RESPONSE TO SUBMISSIONS – SSD 6513 MOD 3 BUILDING R1, BARANGAROO SOUTH

This letter has been prepared by Ethos Urban (formerly JBA) on behalf of Lend Lease Millers Point in relation to the section 96(1A) application (MOD 3) to modify SSD6513 being Building R1, Barangaroo South.

This letter provides a response to the submission made by the City of Sydney, dated 4 October 2017, and information requested by the Department of Planning and Environment (the Department) via email dated 3 October 2017. Each issue is addressed under separate heading below.

1. SEE CAD MODEL FOR OTHER DIMENSIONS
2. ALL DIMENSIONS IN mm
3. TOLERANCE UNLESS SPECIFIED OTHERWISE
LINEAR: ±0.20
ANGULAR: 0.5

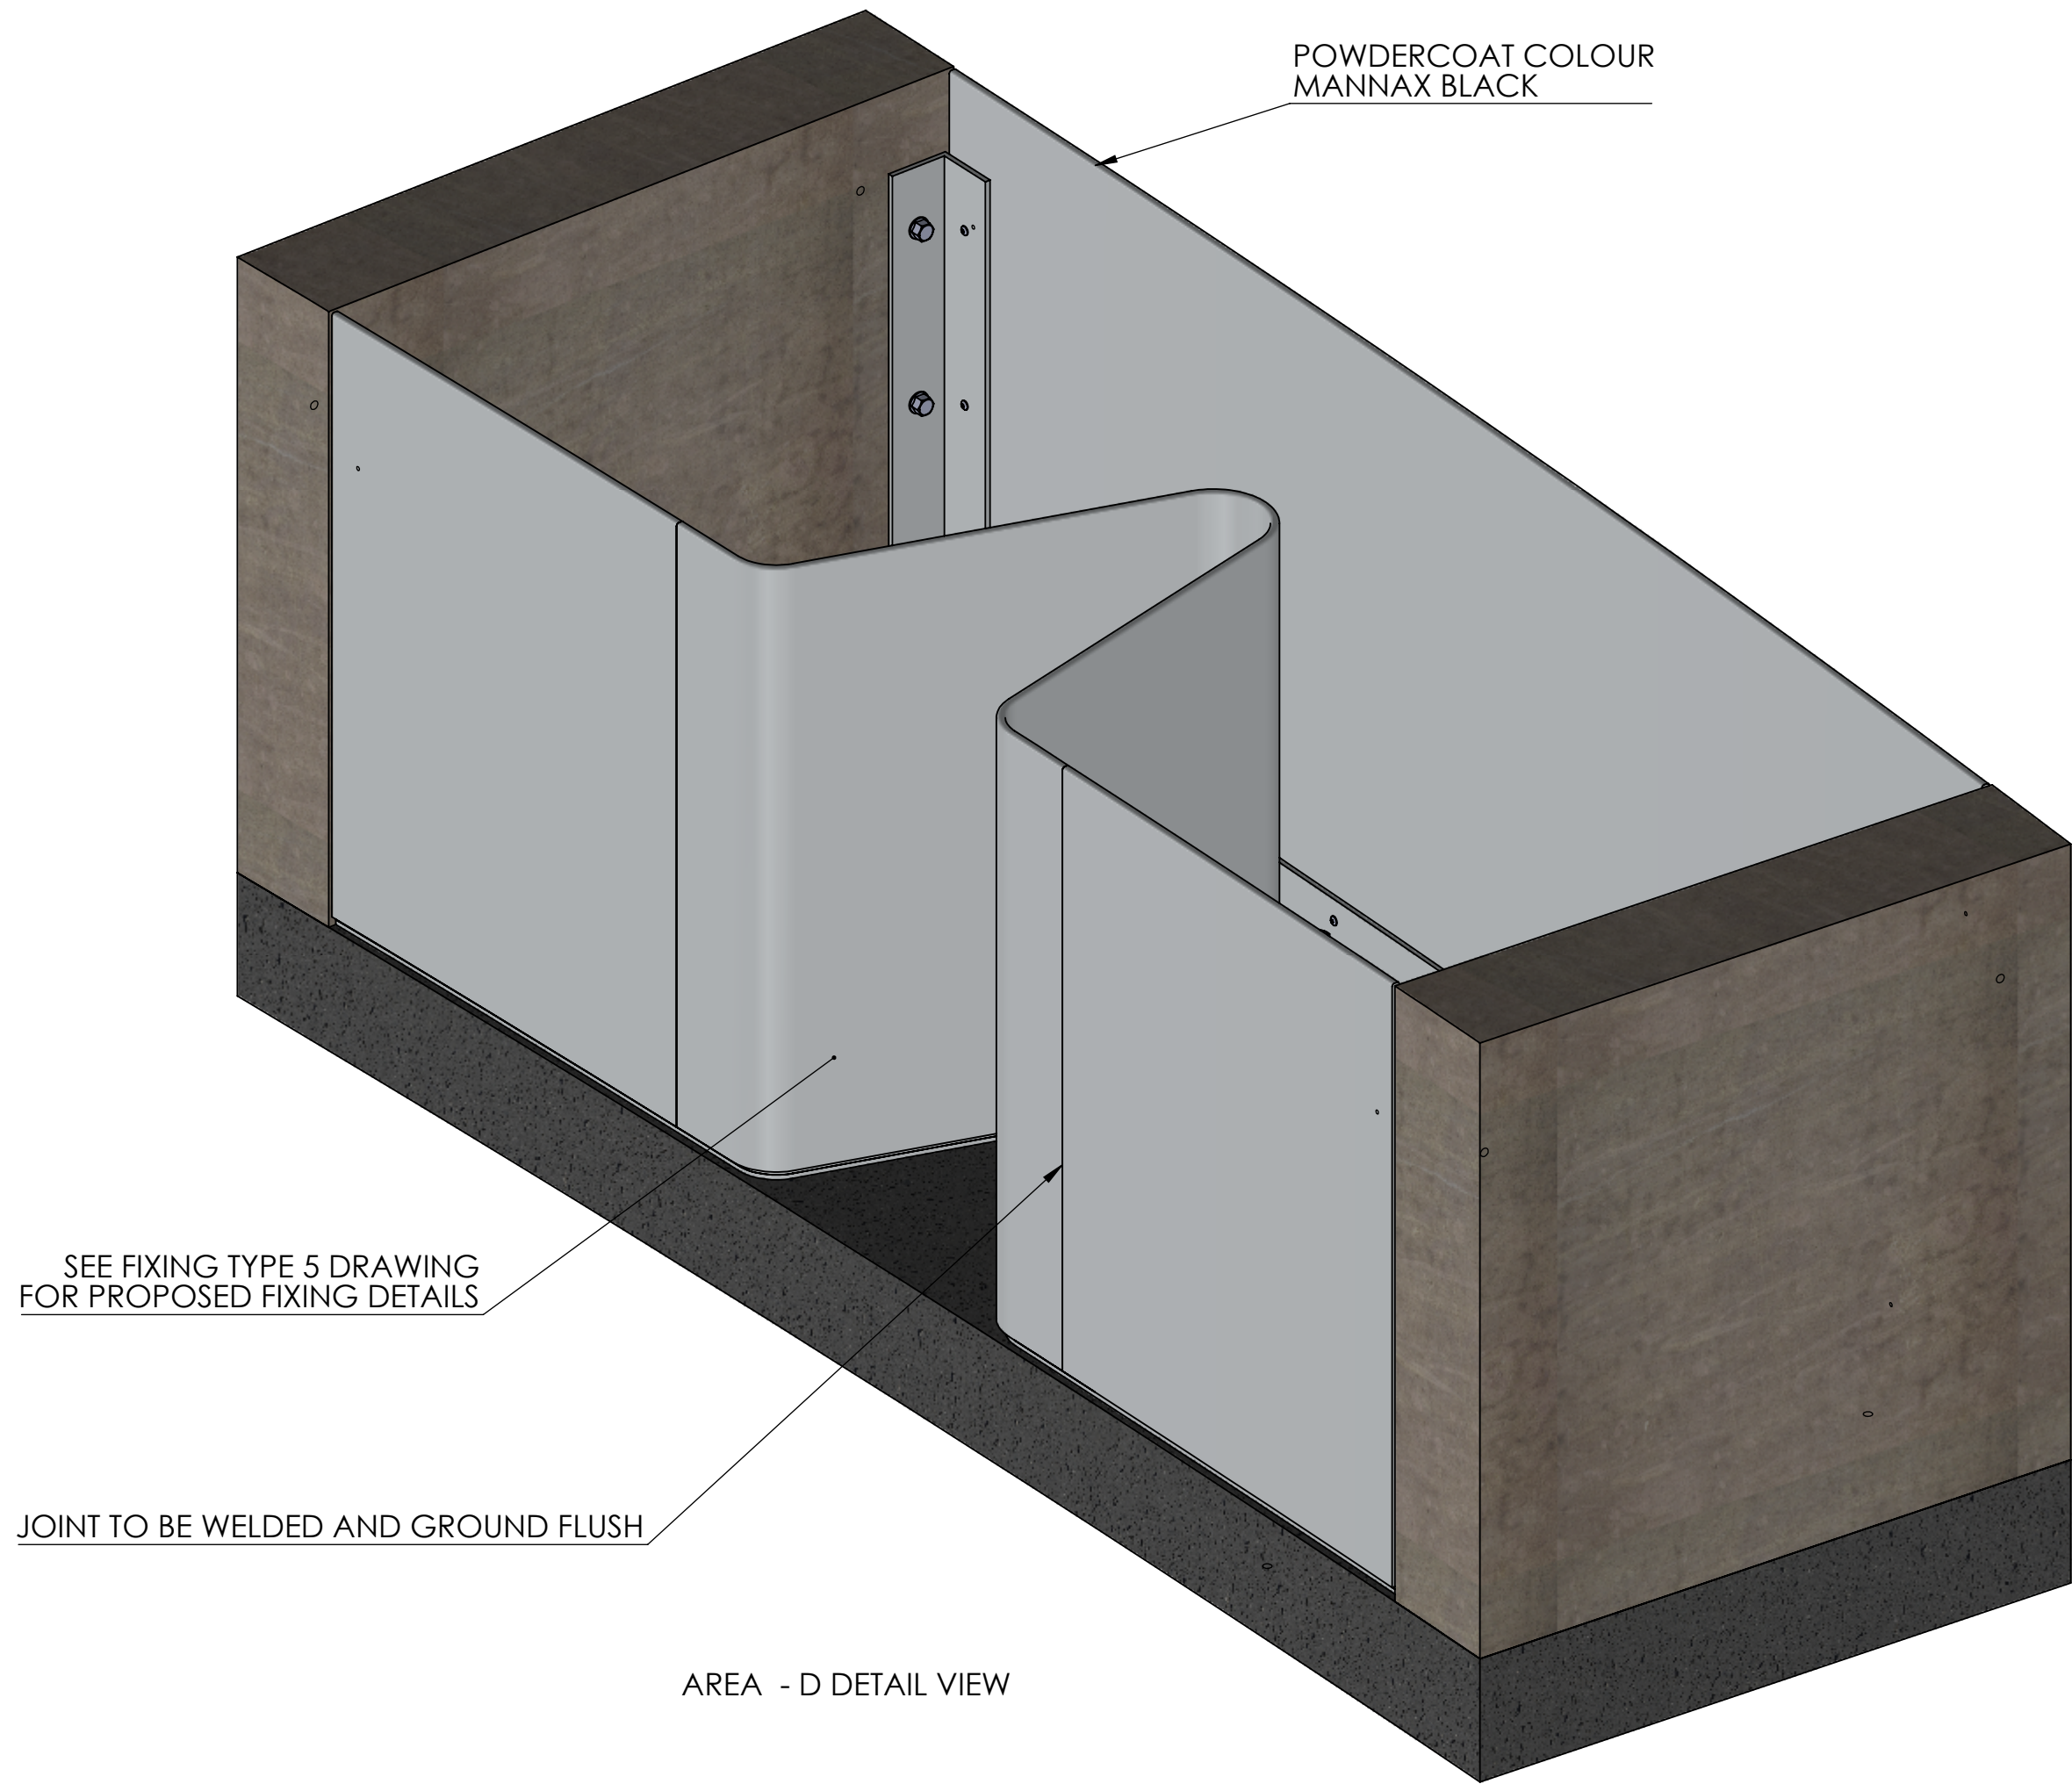
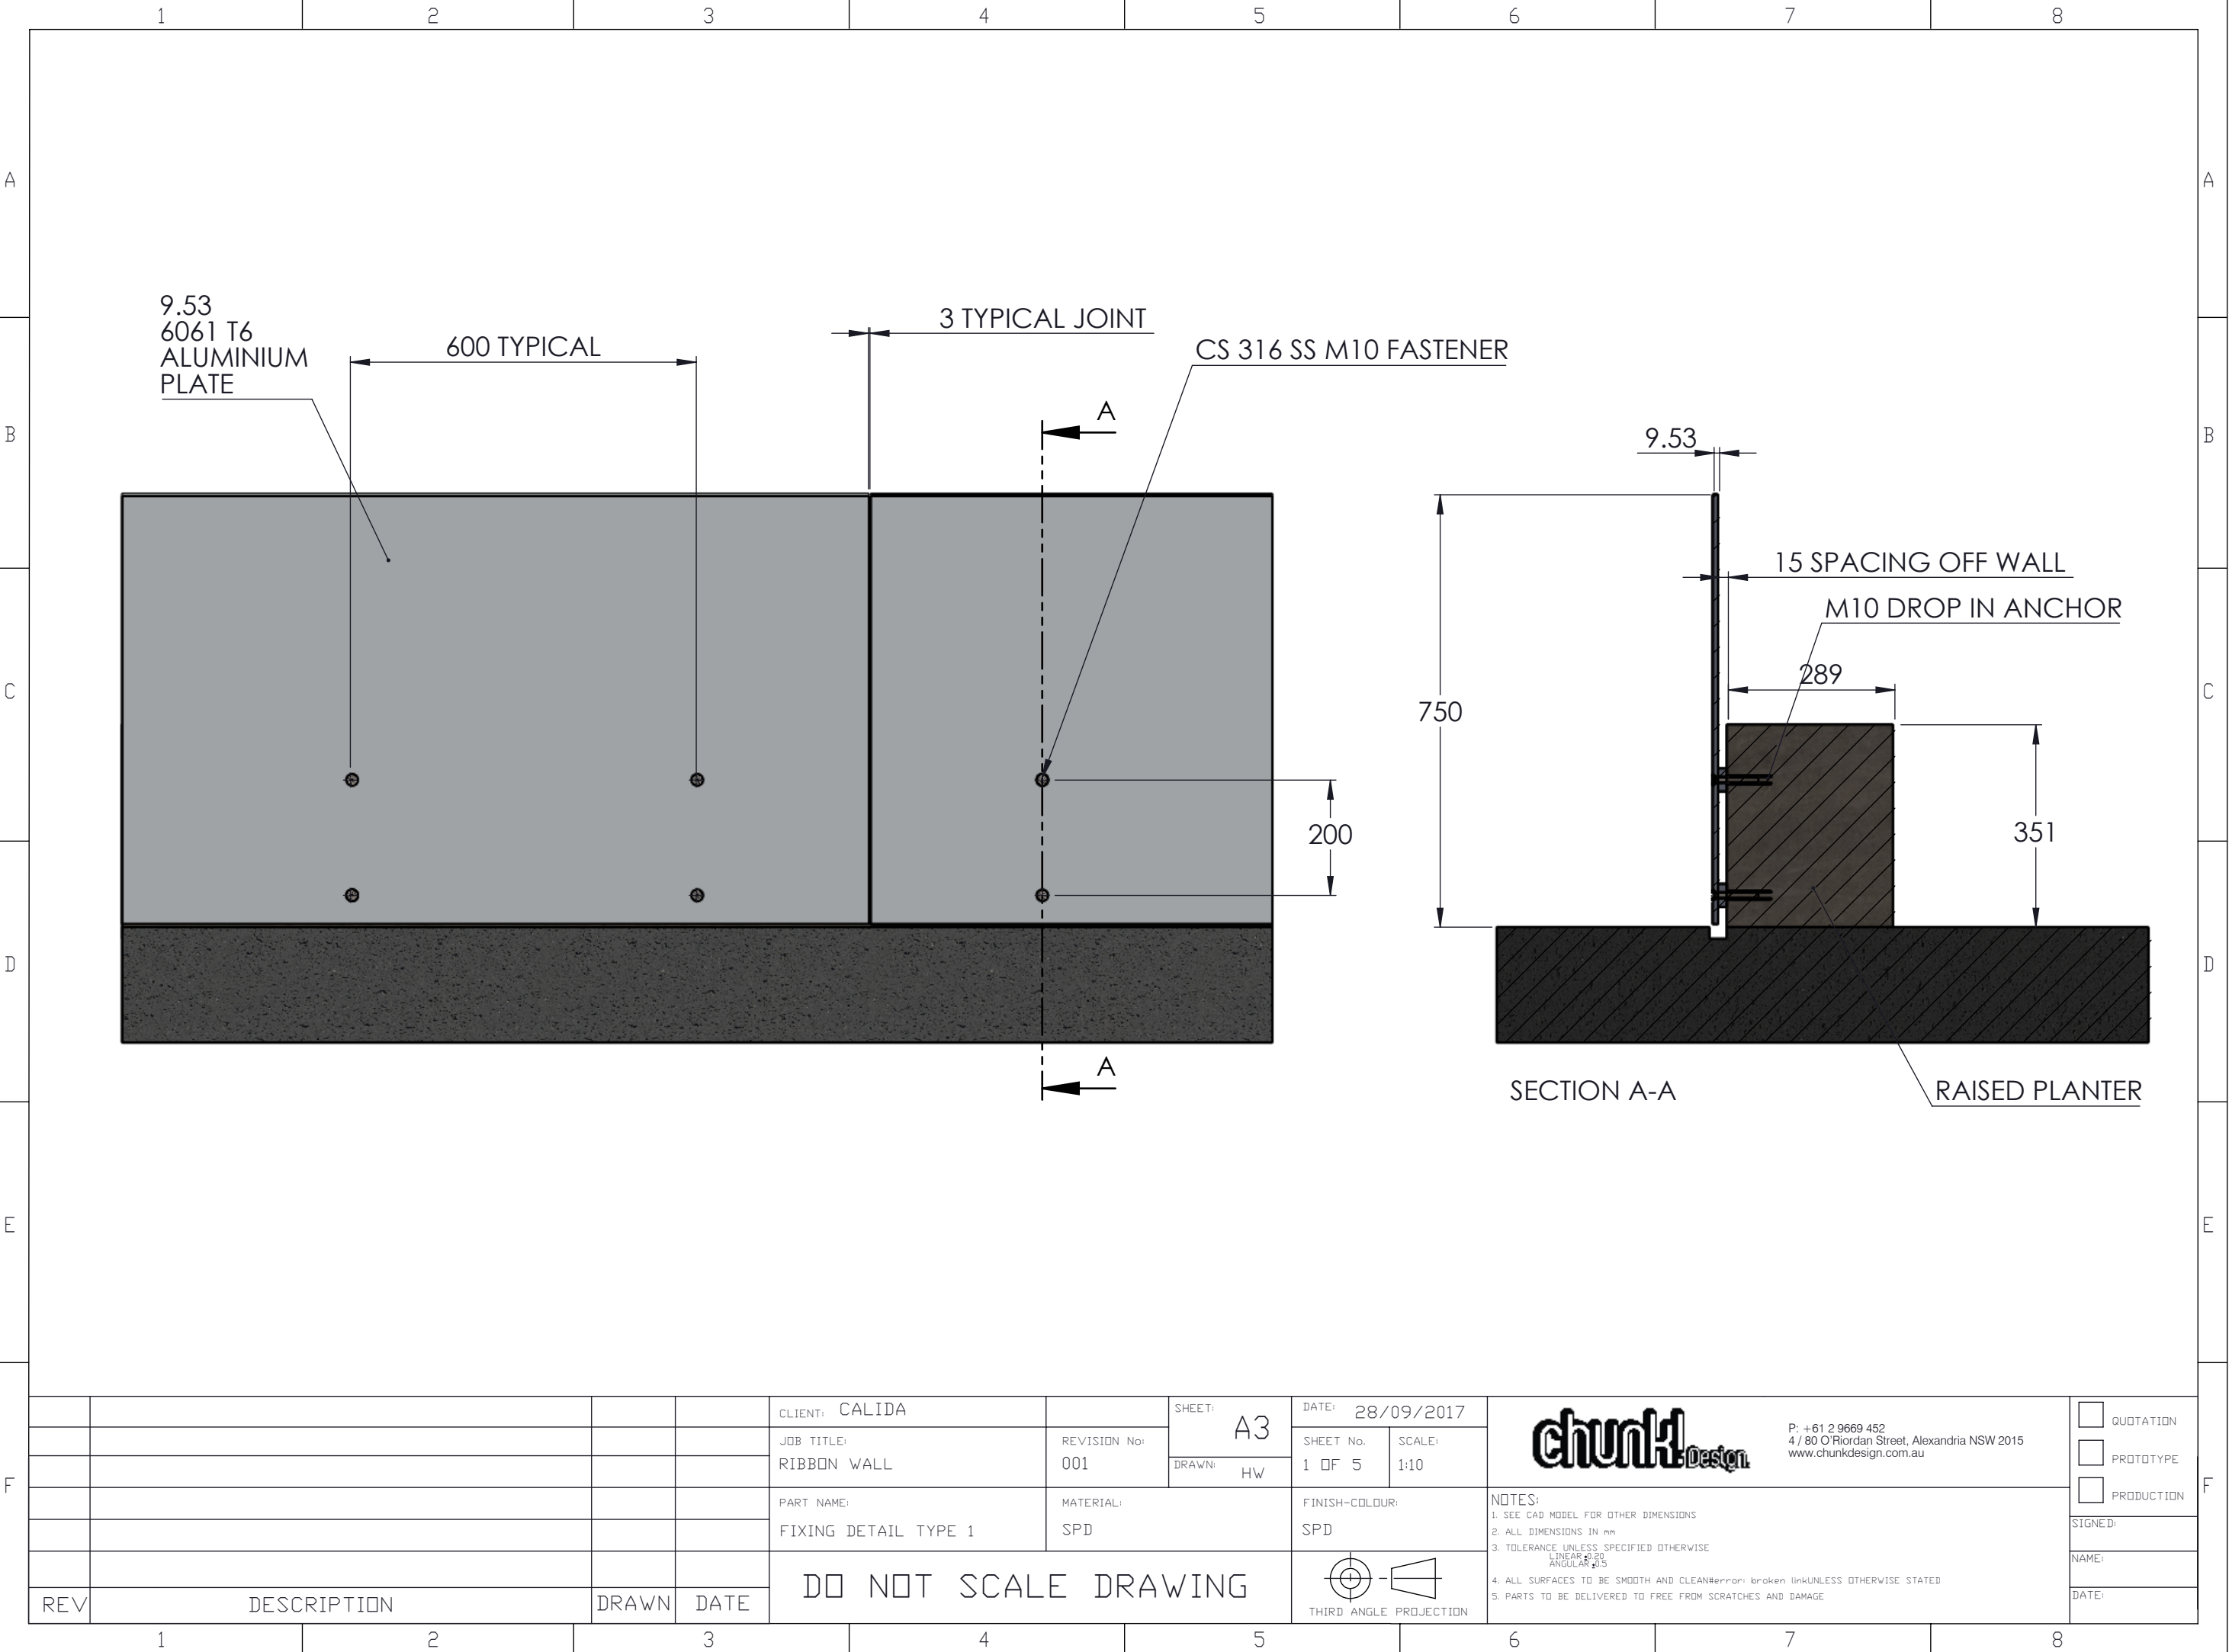
Folded Metal Planter Details

Additional 'for information' diagrams have been prepared and submitted at **Attachment A** to demonstrate the proposed installation of the folded metal planter boxes demarcating the outdoor areas of the ground floor seating from the public domain of Barangaroo South.
